3 October 2017

File No: R/2017/8/B  
Our Ref: 2017/479514

### **Concept Proposal for the Over Station Development at Martin Place Metro Station (SSD 8351) – Response to Submissions**

MARTIN PLACE VIEW ANALYSIS

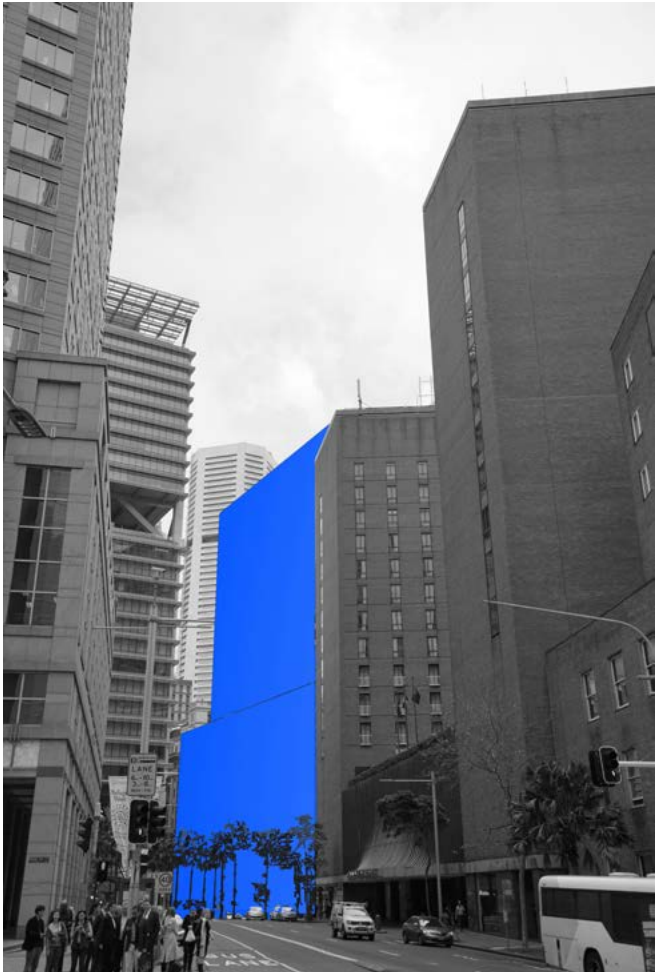
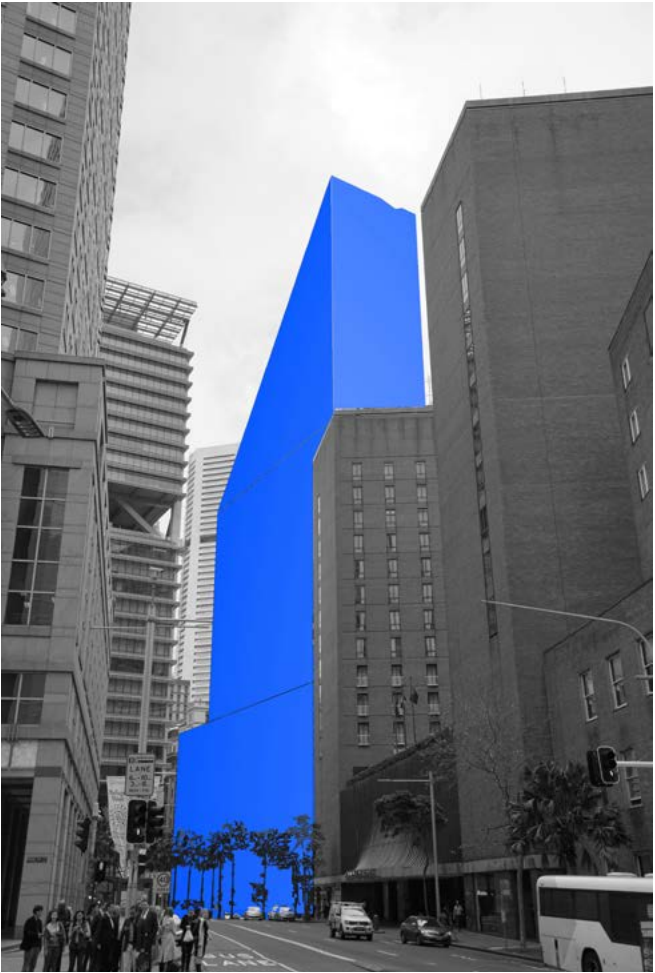
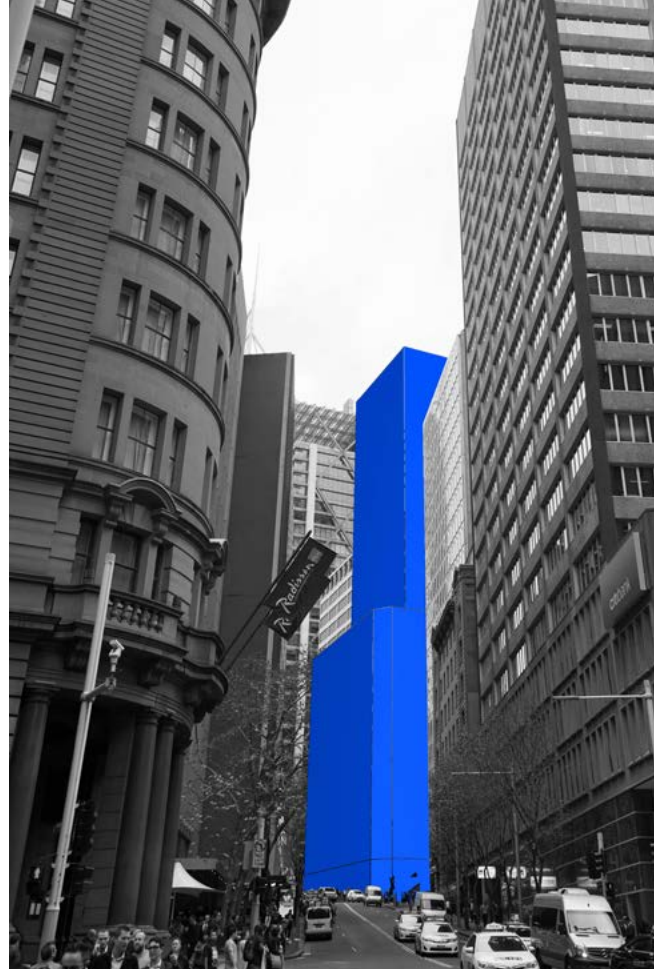
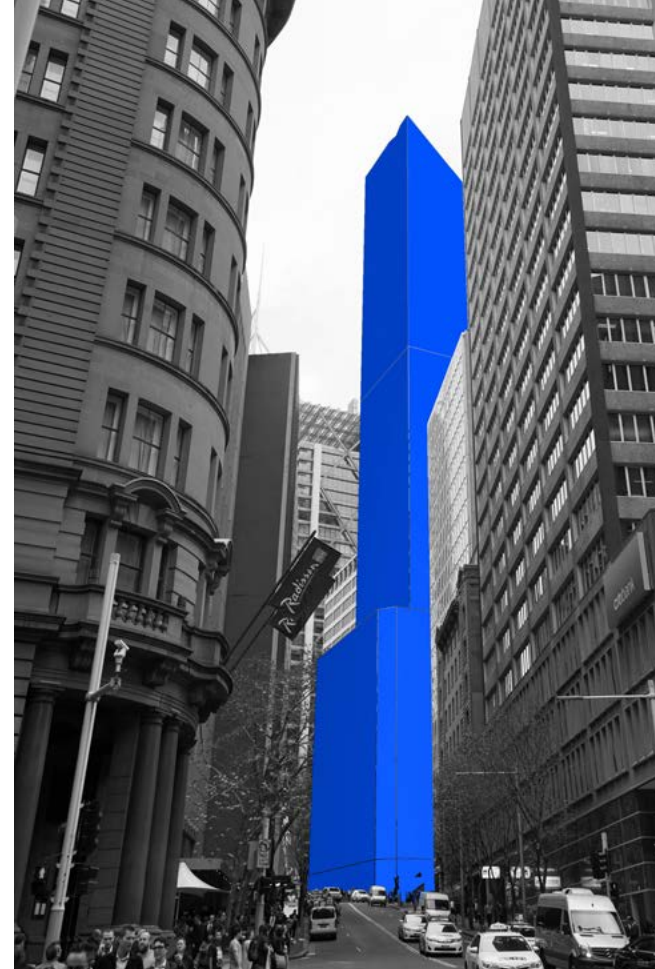
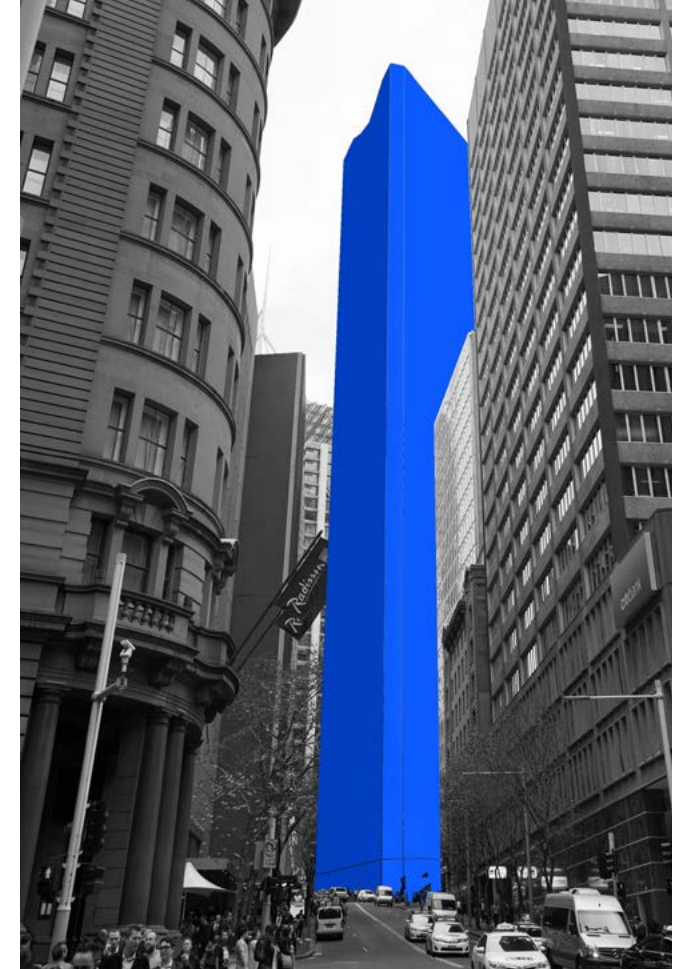
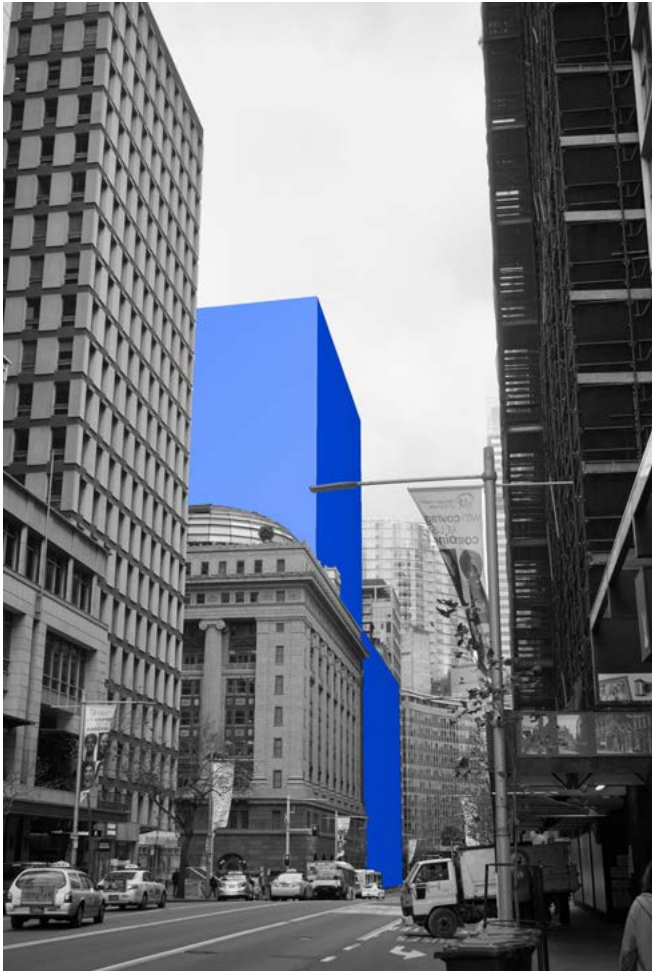
The provided 'Key Public View' and Shadow Analysis provided with the RTS do not provide adequate justification for the variation to the east and west tower setbacks required in Sydney DCP 2012.
